CITY OF ALBUQUERQUE

July 20, 2016

**Re: Beehive at Montano
Traffic Circulation Layout**
Engineer's/Architect's Stamp dated 7-19-16 (E10-D027)

## PROPOSED SITE PLAN

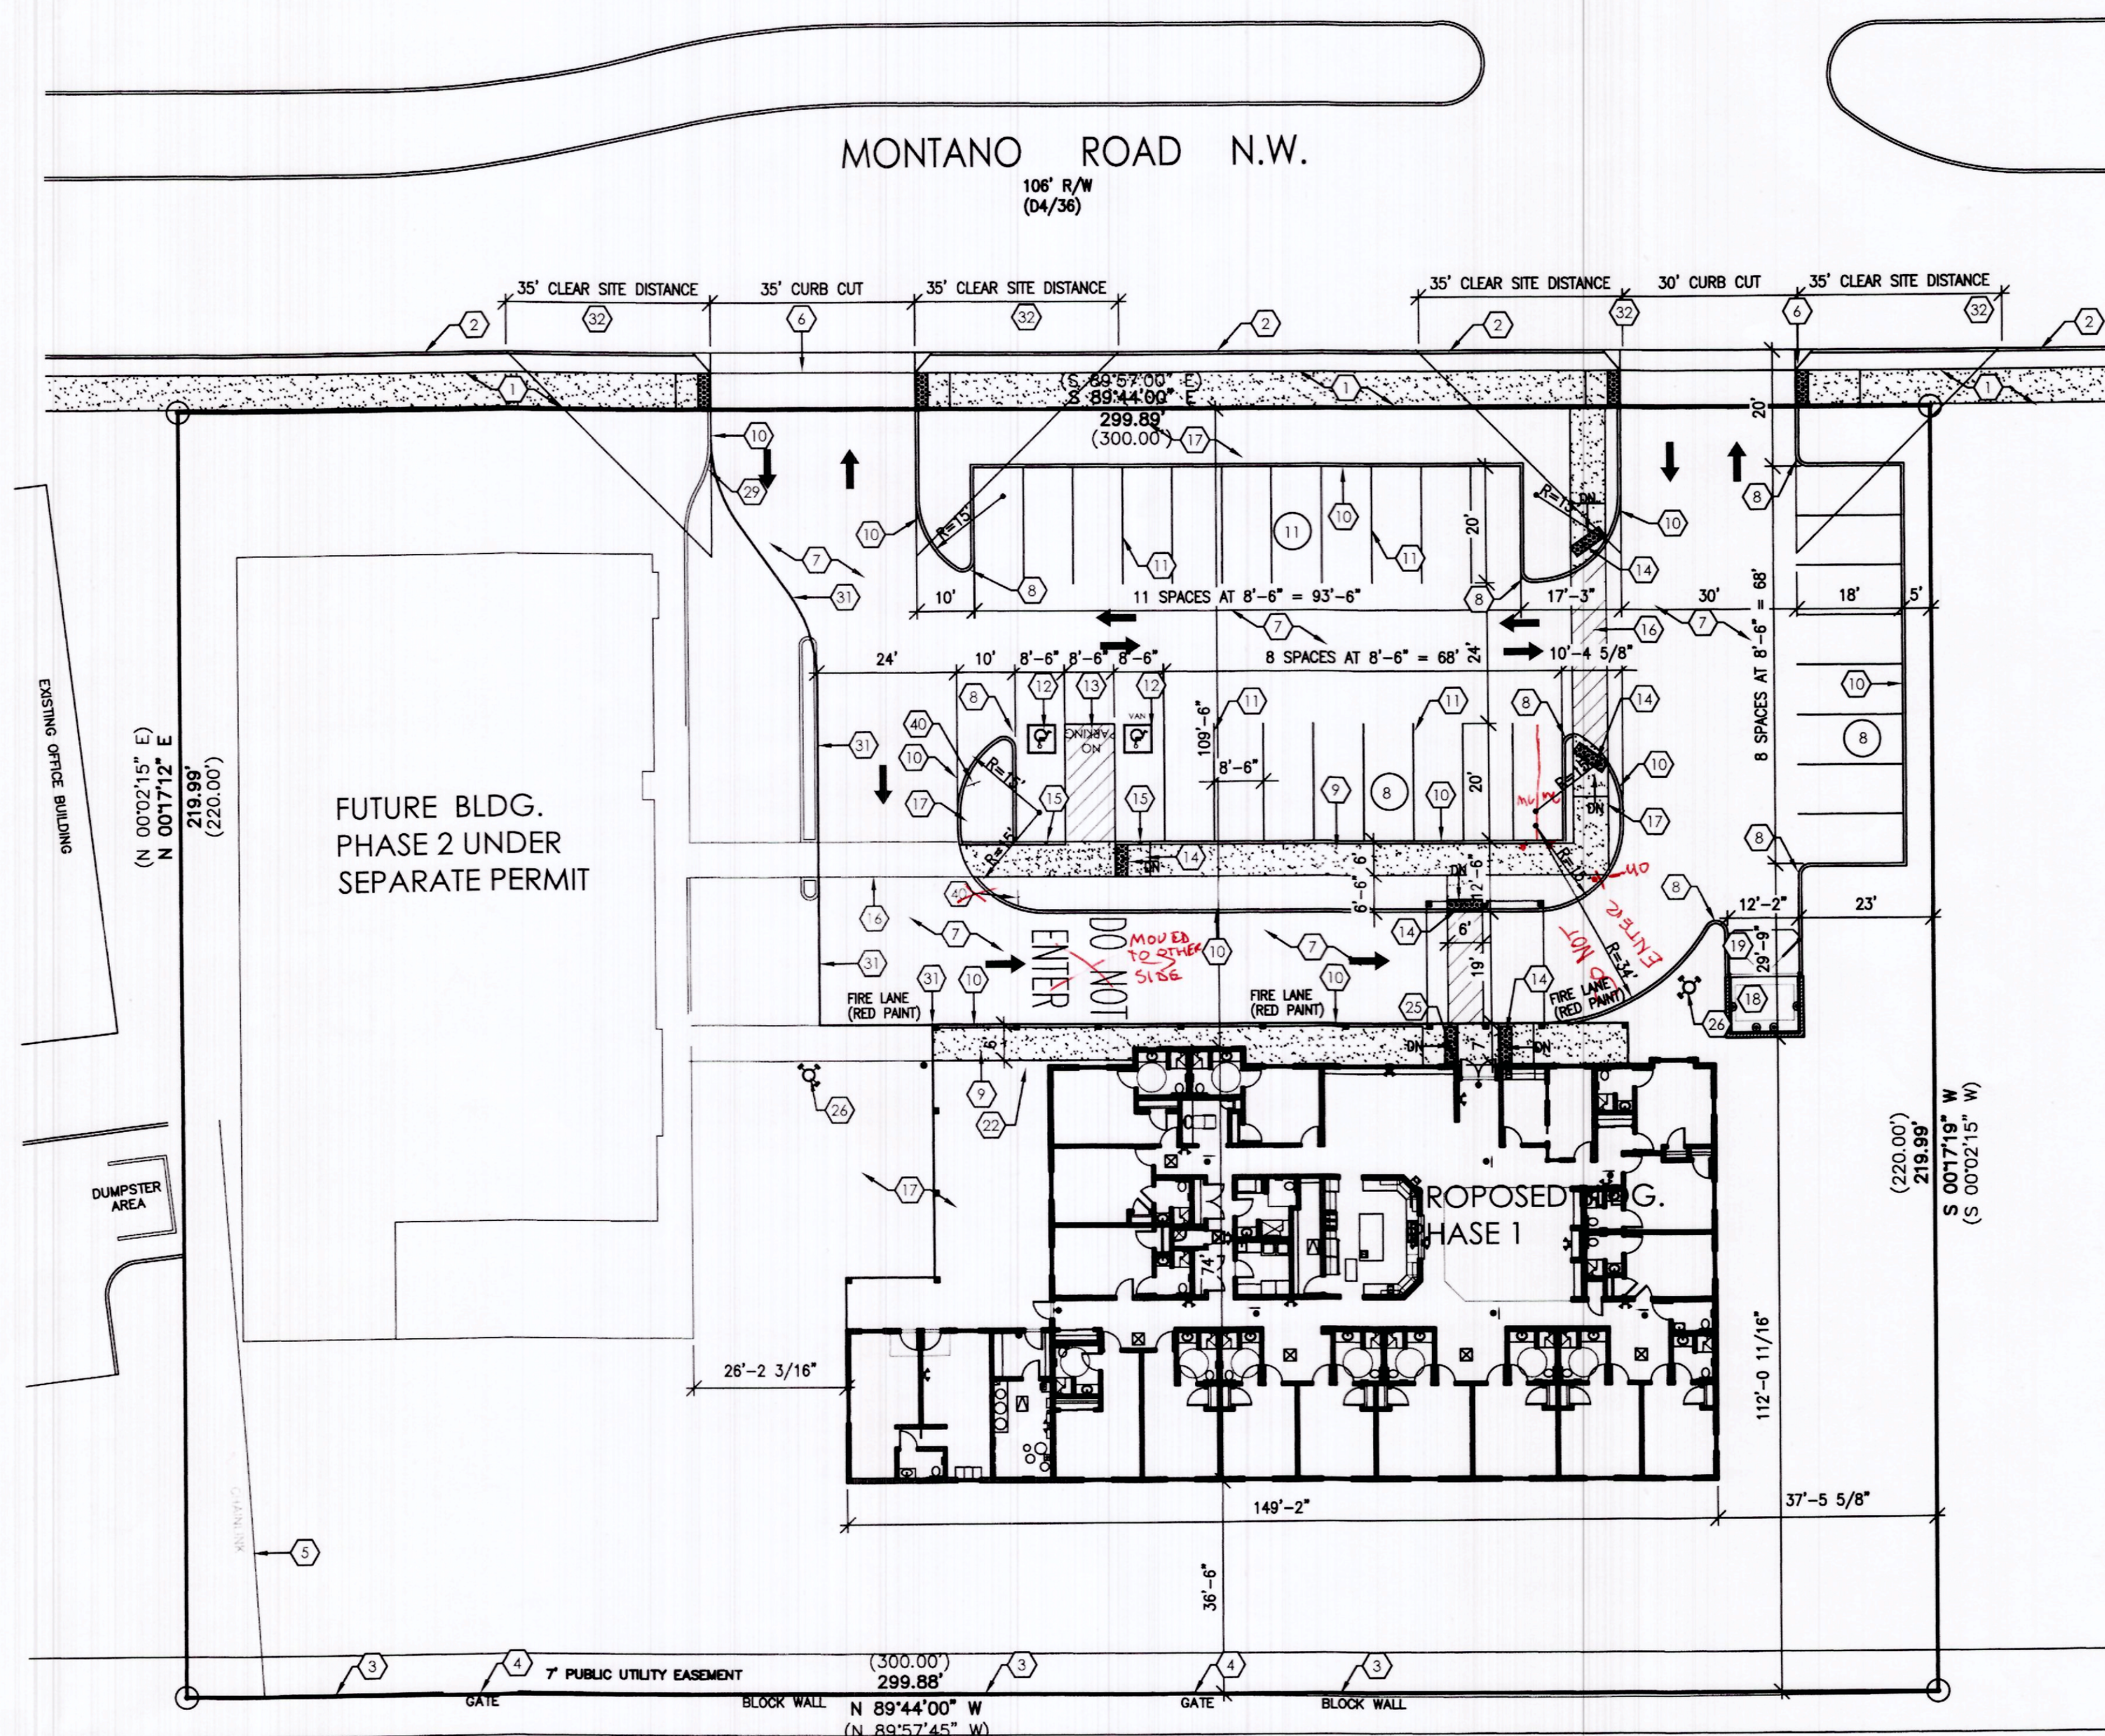
1. Please review and revise plan to align the north east curb cut on Montano Rd. to the existing medians.
2. Please include two copies of the traffic circulation layout at the next submittal.
